Office of Environment & Heritage

PA 08-0101 & 08-0102 MOD 4
DOC14/84219-01; EF14/1155
Ziggy Andersons, 4908 6820

RE: OEH REVIEW OF INTEGRA COAL MINING COMPLEX - MODIFICATION 4 (MP 08-0101 & MP 08-0102) - REVISED BIODIVERSITY OFFSET PACKAGE

Vegetation communities in the revised onsite biodiversity offset areas
Integra Mine Complex Modification 4 Revised Biodiversity Offset Strategy

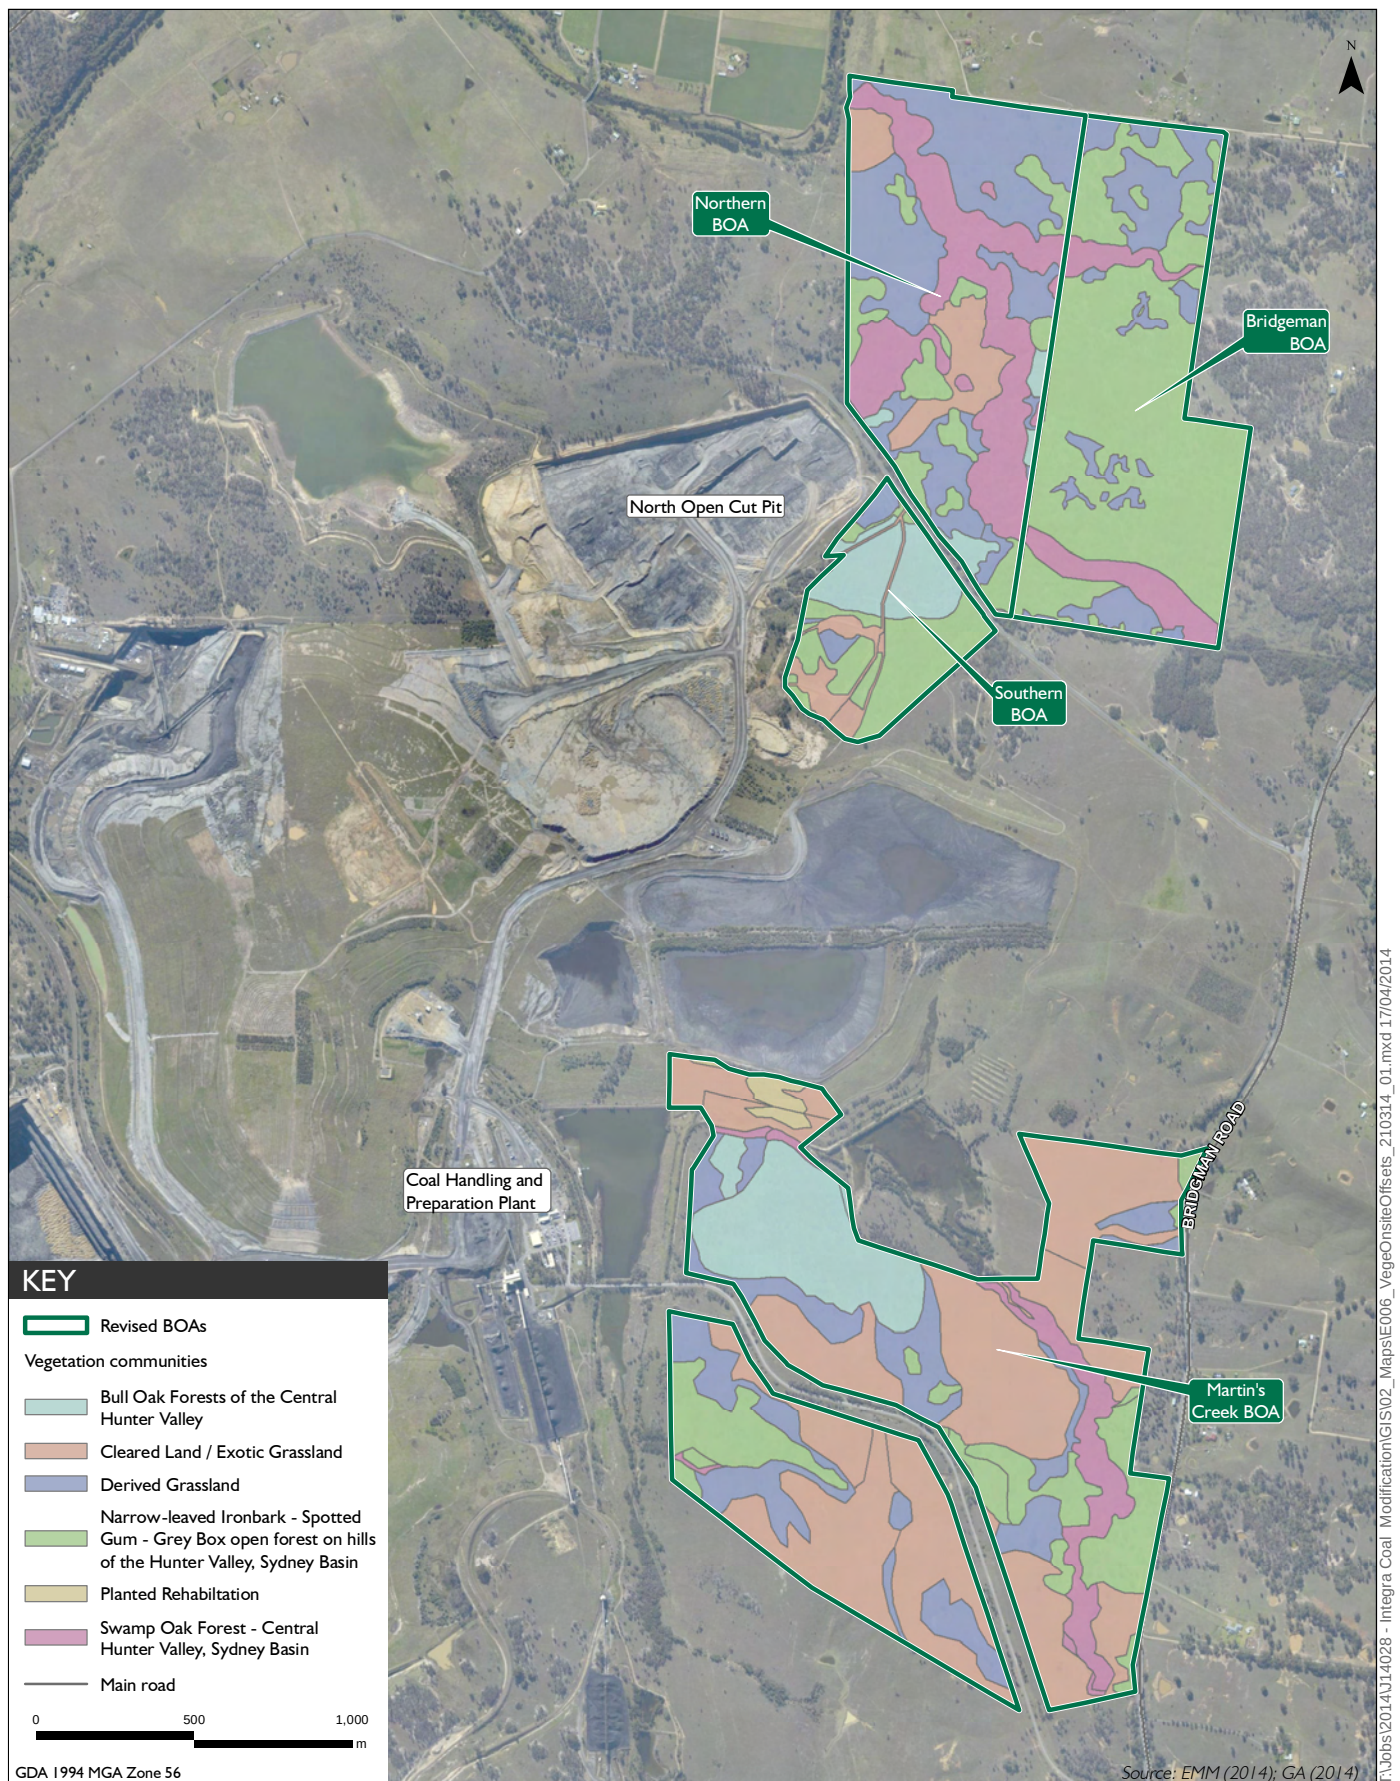
OEH acknowledges that the revised package satisfies Schedule 3 Condition 42 of the current combined consent in regards to the areas of offsets to be provided but this is based on the assumption that the proposed rehabilitation of Narrow-leaved Ironbark – Spotted Gum – Forest Red Gum Forest is a suitable surrogate for remnant vegetation (see **Table 2**). Passive management of the Derived Grassland/Native Pasture does not guarantee that it will over time become the Narrow-leaved Ironbark – Spotted Gum – Forest Red Gum Forest community. Active management including a combination of planting of seedlings and direct seeding will be required to ensure the offset commitments will be met.

In consideration of the above OEH does not object to the revised offset package, but due to the reliance on the rehabilitation of Narrow-leaved Ironbark – Spotted Gum – Forest Red Gum Forest to meet the conditions of consent, OEH recommends that the conditions of consent for the submitted modification include:

- Integra Coal Operations Pty Ltd must commit to actively revegetating the entirety of the proposed 87.2 hectares (ha) of rehabilitation to Narrow-leaved Ironbark – Spotted Gum – Forest Red Gum Forest and identify the timeframe in which this will occur;
- An update of the Integra Complex Biodiversity Management Plan (EMP-2016 Biodiversity Management Plan) to include:
 - Details of the revised Biodiversity Offset Strategy, including the revised Biodiversity Offset Areas;
 - Definition of the boundaries of the 87.2 ha of Derived Grassland/Native Pasture that are proposed to be rehabilitated;

- A program of works to actively rehabilitate the entirety of the 87.2ha of Derived Grassland/Native Pasture to Narrow-leaved Ironbark – Spotted Gum – Forest Red Gum Forest that includes:

- the proposed methods to rehabilitate the 87.2 ha of Derived Grassland/Native Pasture;
 - the location and staging of active rehabilitation methods;
 - the proposed planting densities and percentage composition of individual species used in rehabilitation;
